From: Hardie, Simon <Simon.Hardie@lancashire.gov.uk>
Sent: 17 March 2021 17:22
To: John Macholc <John.Macholc@ribblevalley.gov.uk>
Cc: Bloomer, David <David.Bloomer@lancashire.gov.uk>
Subject: RE: 3/2021/0230

We are OK with the principle of the bridge repairs, however we would require a Section 278 agreement for the works to the surfacing of the bridge deck, and the associated footways kerbing bollards etc. there are concerns regarding the proposed pedestrian barriers which can be addressed during the 278 consultation prior to the agreement being signed.

North West Structures DJH/12		
BROWNHILL PROPOSED GENERAL ARRANGEMENT 1 OF 2		
SCALES		
As Shown	SURVEY GRID SD 684 309	REVISION
DRAWING NUMBER	B92118-DRG-BRS1004	P01

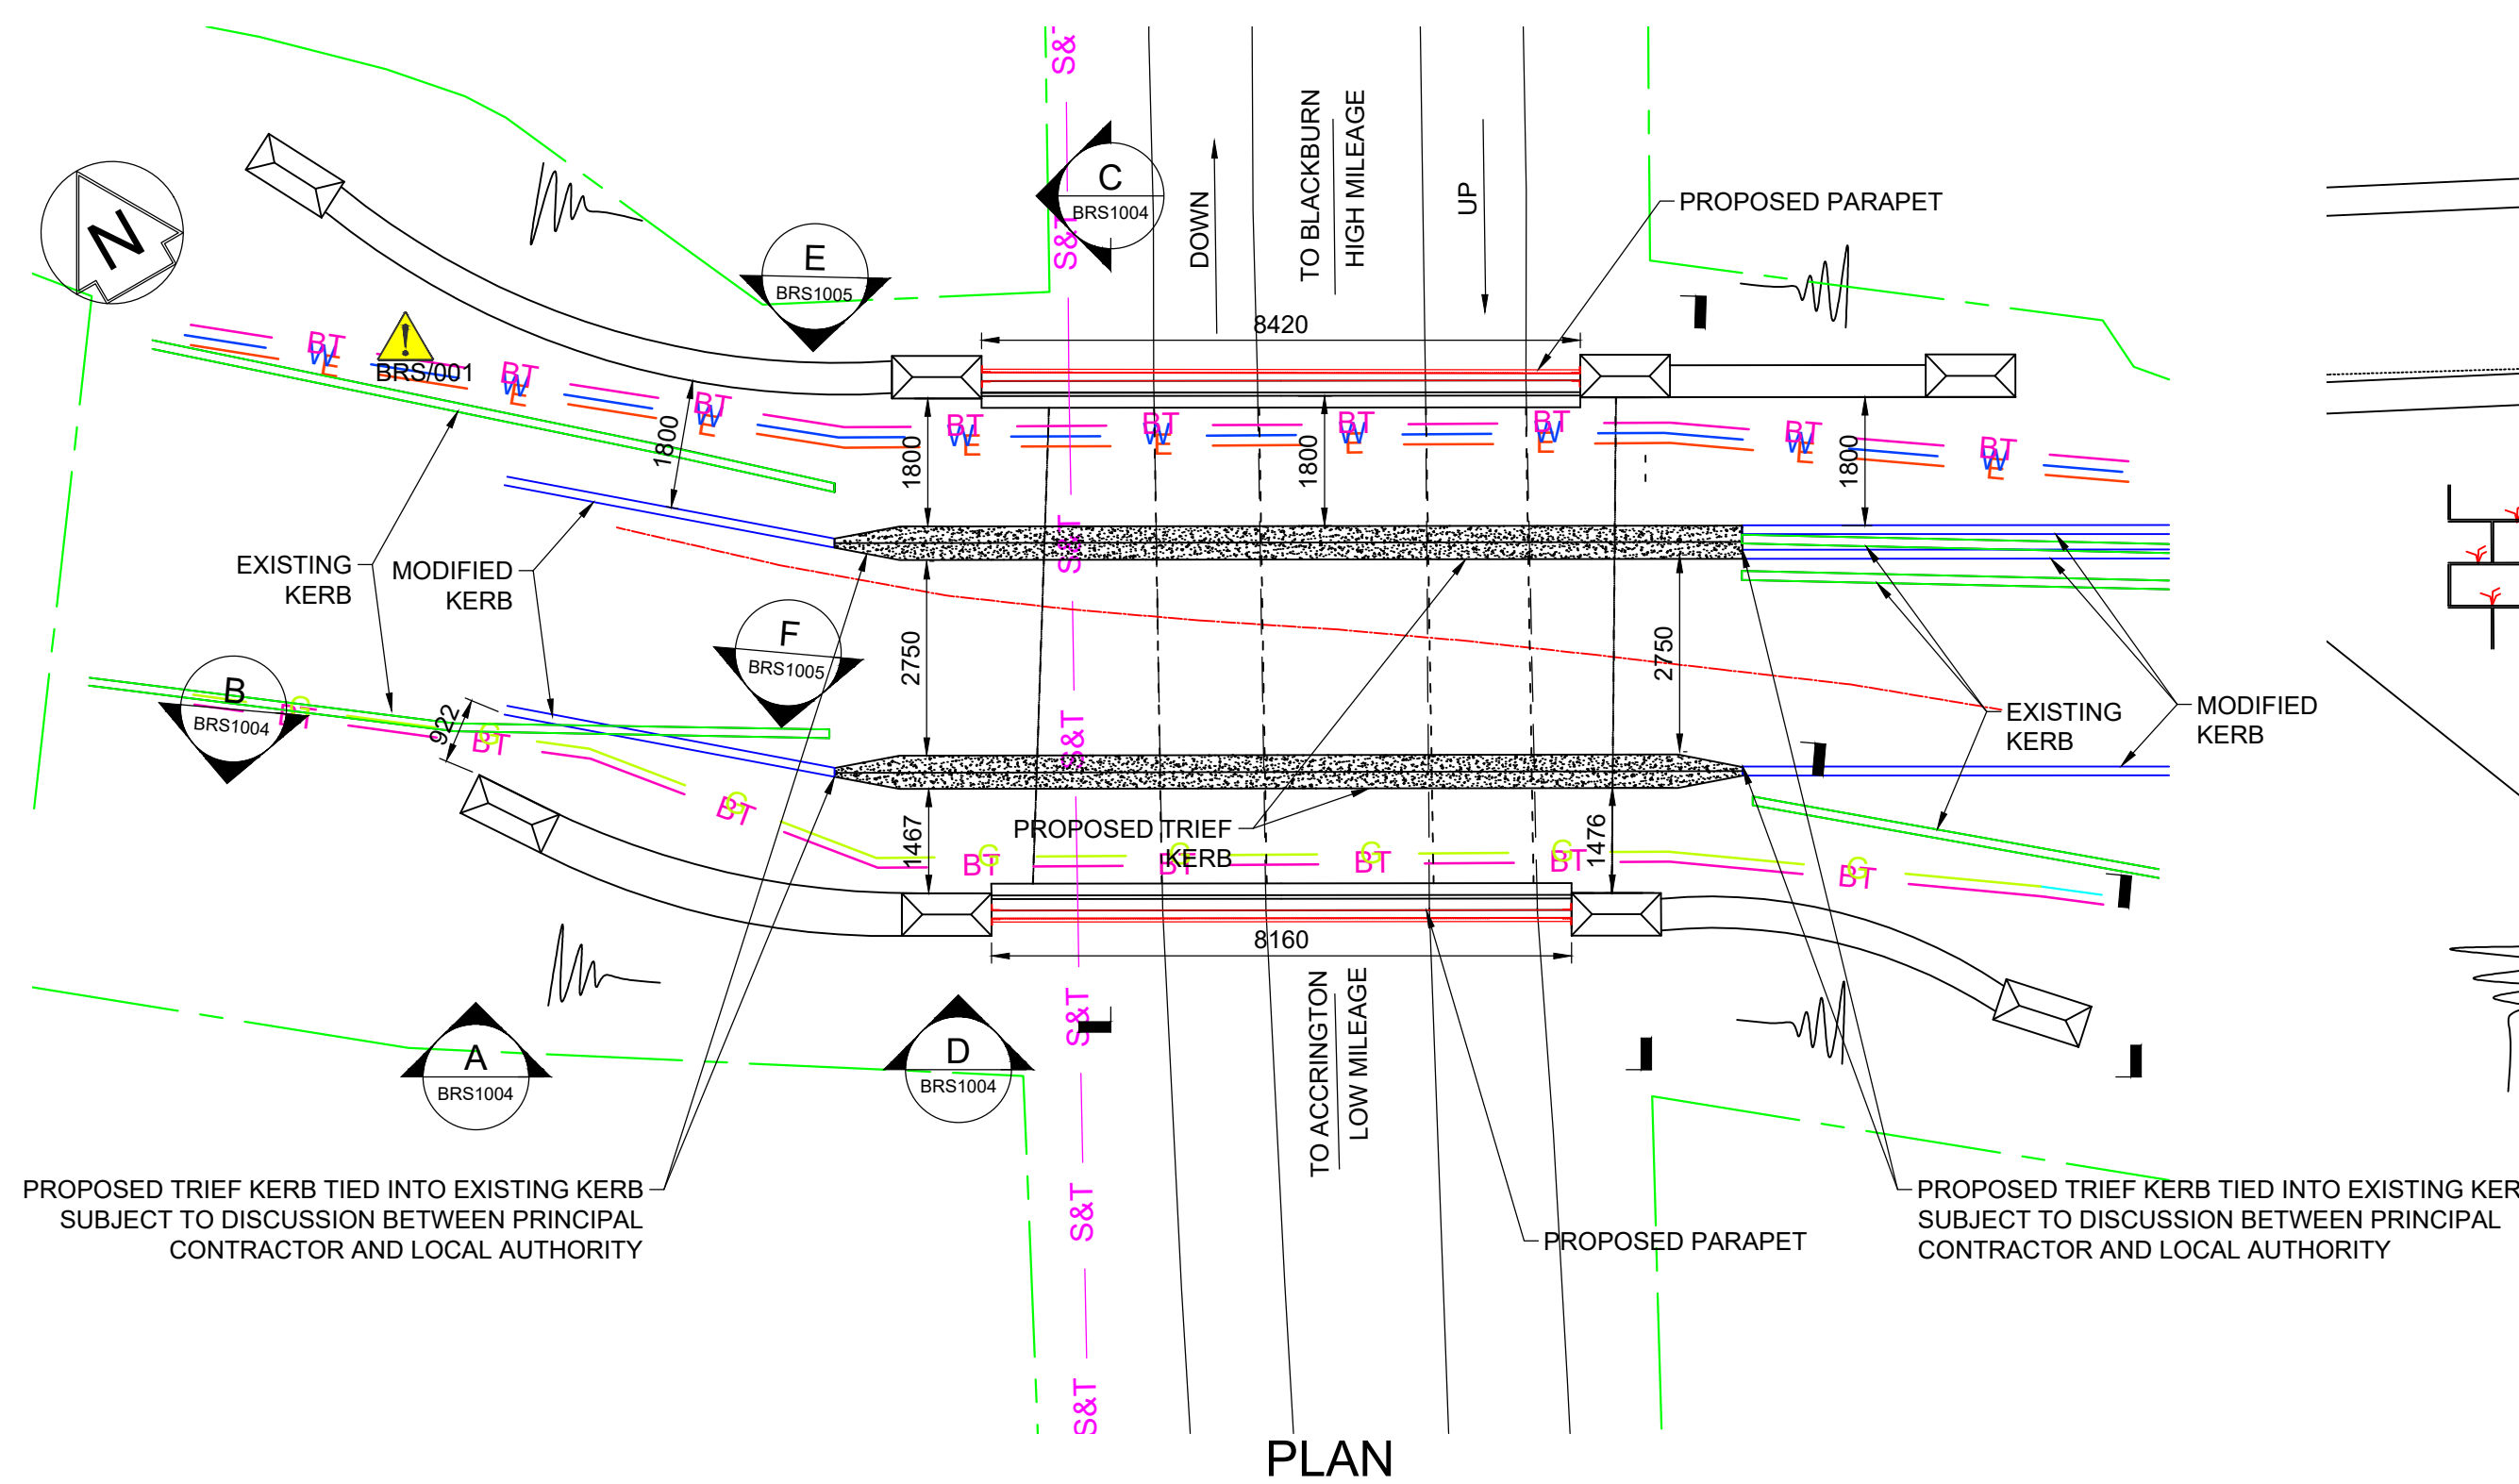
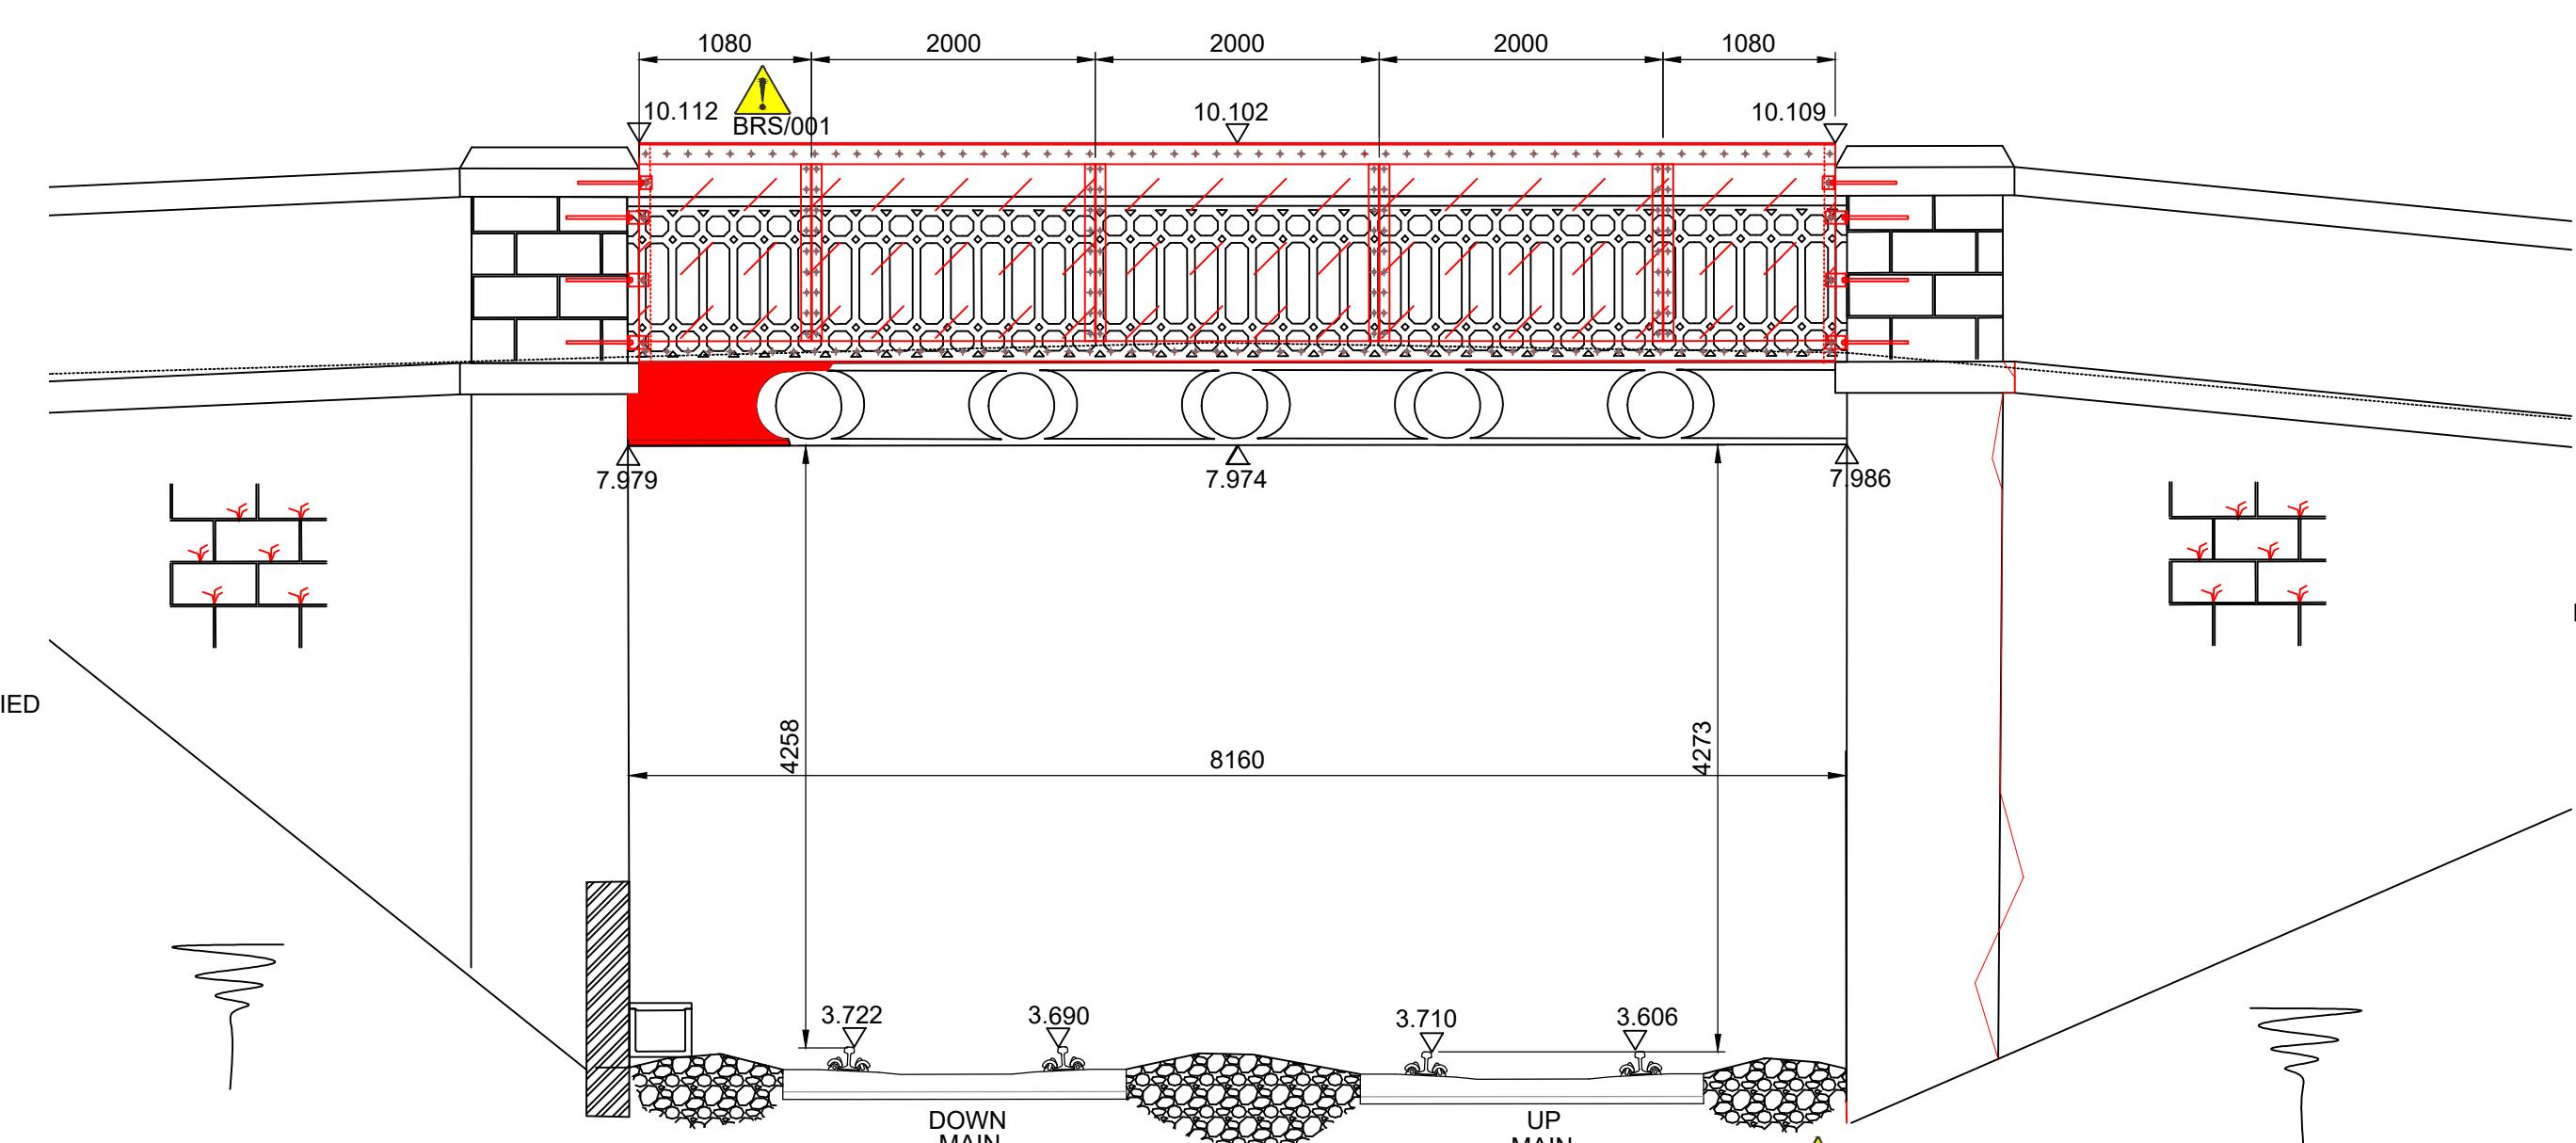
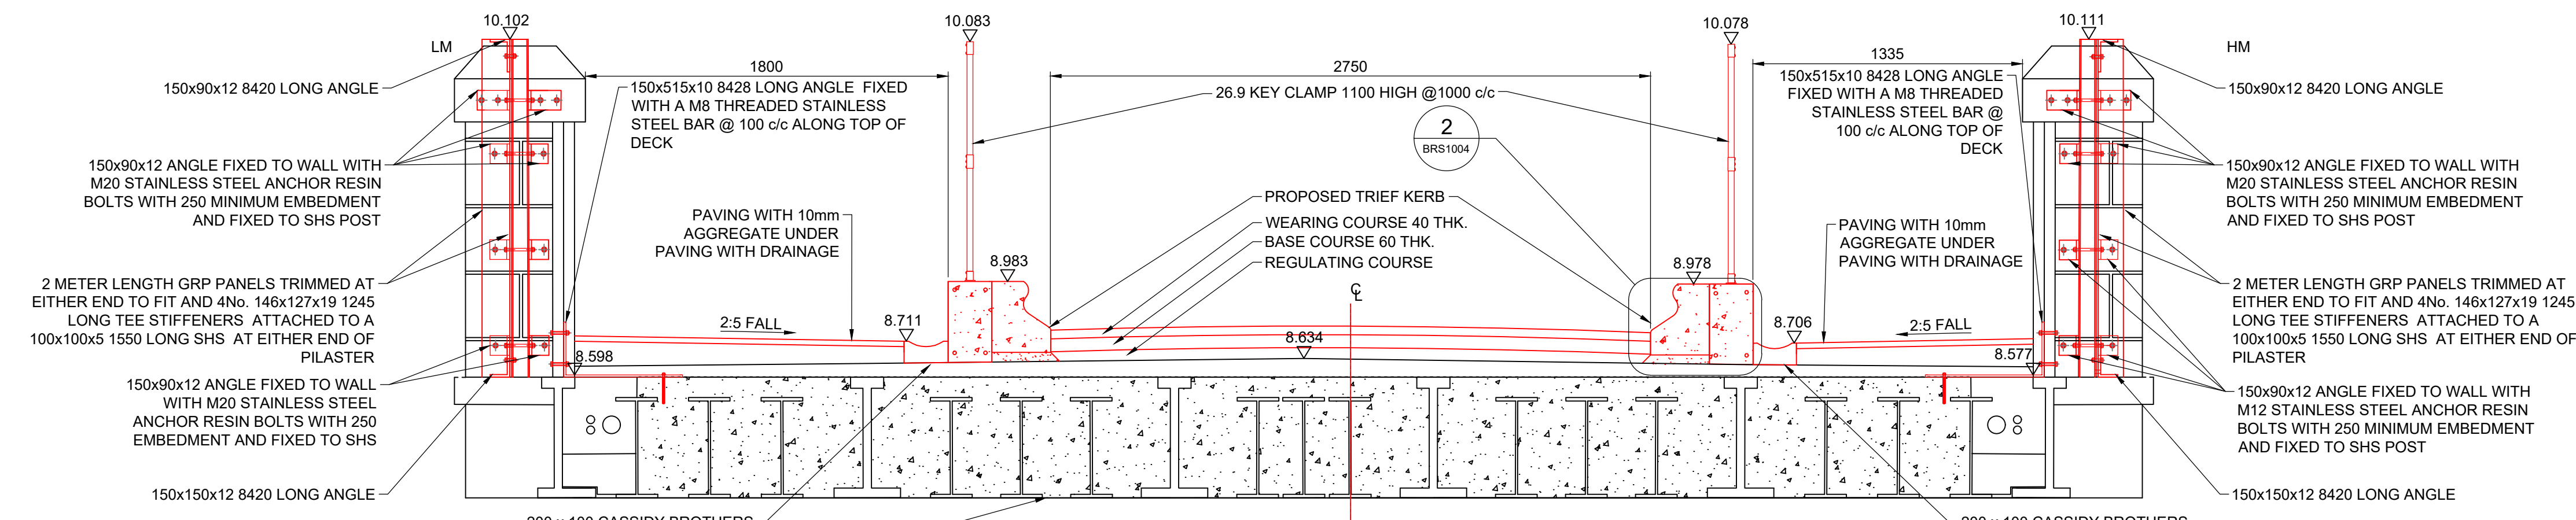
There are a number of questions regarding the narrowing of carriageway, suitability of the approach for larger vehicles including refuse collection by RVBC, diversion route during the in potential road closure, temporary pedestrian crossing to allow access to the station and bus routes on the A666. This is not a comprehensive list of concerns as the full extents and implications of the works is not known.
